Engineers Comments Regarding Surface Water Drainage

Application Reference:	WA/86/25/DOC	Reviewer Reference:	ADC/EXT5/AF
Planning Officer:	Amber Willard	Date of Review:	10/12/2025
Site Name:	Barnfield House Arundel Road Walberton BN18 0SD		
Application Description:	Approval of details reserved by condition imposed under reference WA/58/23/S73 relating to condition 9 - as-built drawings of surface water drainage scheme (see WA/85/25/DOC for conditions 12 - cycle parking and 18 - acoustic testing).		
Assessment Number:	2

Application Reference: WA/86/25/DOC Site Name: Barnfield House Arundel Road Walberton BN18 0SD	Initial Issue Date: 19/11/2025 Issue Date: 10/12/2025 Reviewer Reference: ADC/EXT5/AF
---	--

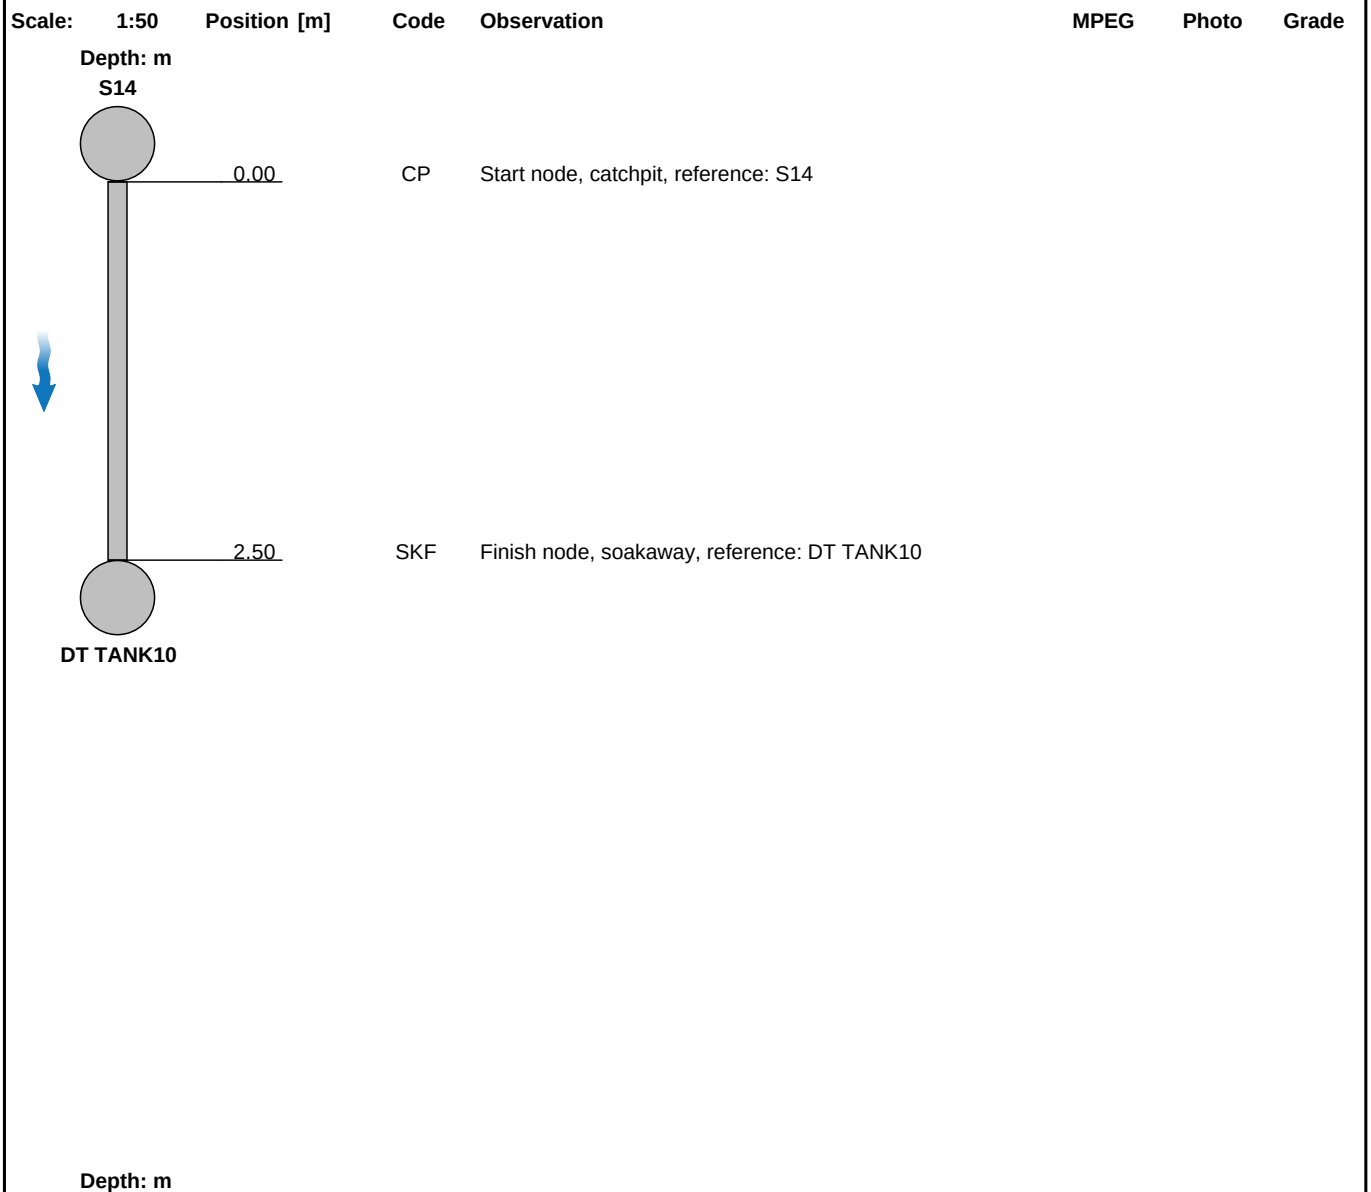
ADC Drainage Comments	ADC Drainage Comments			
Date:	19/11/2025	10/12/2025			
Condition Number: 9					
Comment Number					
1	Photographic evidence should be provided for each permavoid storage and concrete dam installation, with references marked on the plans.	The six permavoid installations are photographed and appear to be the correct size. We cannot confirm from the additional photos provided whether the concrete baffles are all installed. The baffle weep holes between compartments which act as flow controls are currently not evidenced.			
2	Evidence of the depths of voided stone layer should be provided for each compartment.	We cannot confirm from the additional photos provided whether the depths of voided stone are correct.			
3	Evidence of all flow control chambers – product, orifice diameter, IL plus photos of	There is no photograph of S14 installed. The orifice diameters for the flow

internal chamber as installed.	control chamber is not evidenced for S14 or S18.			
--	--------------------------------	--	--	--	--
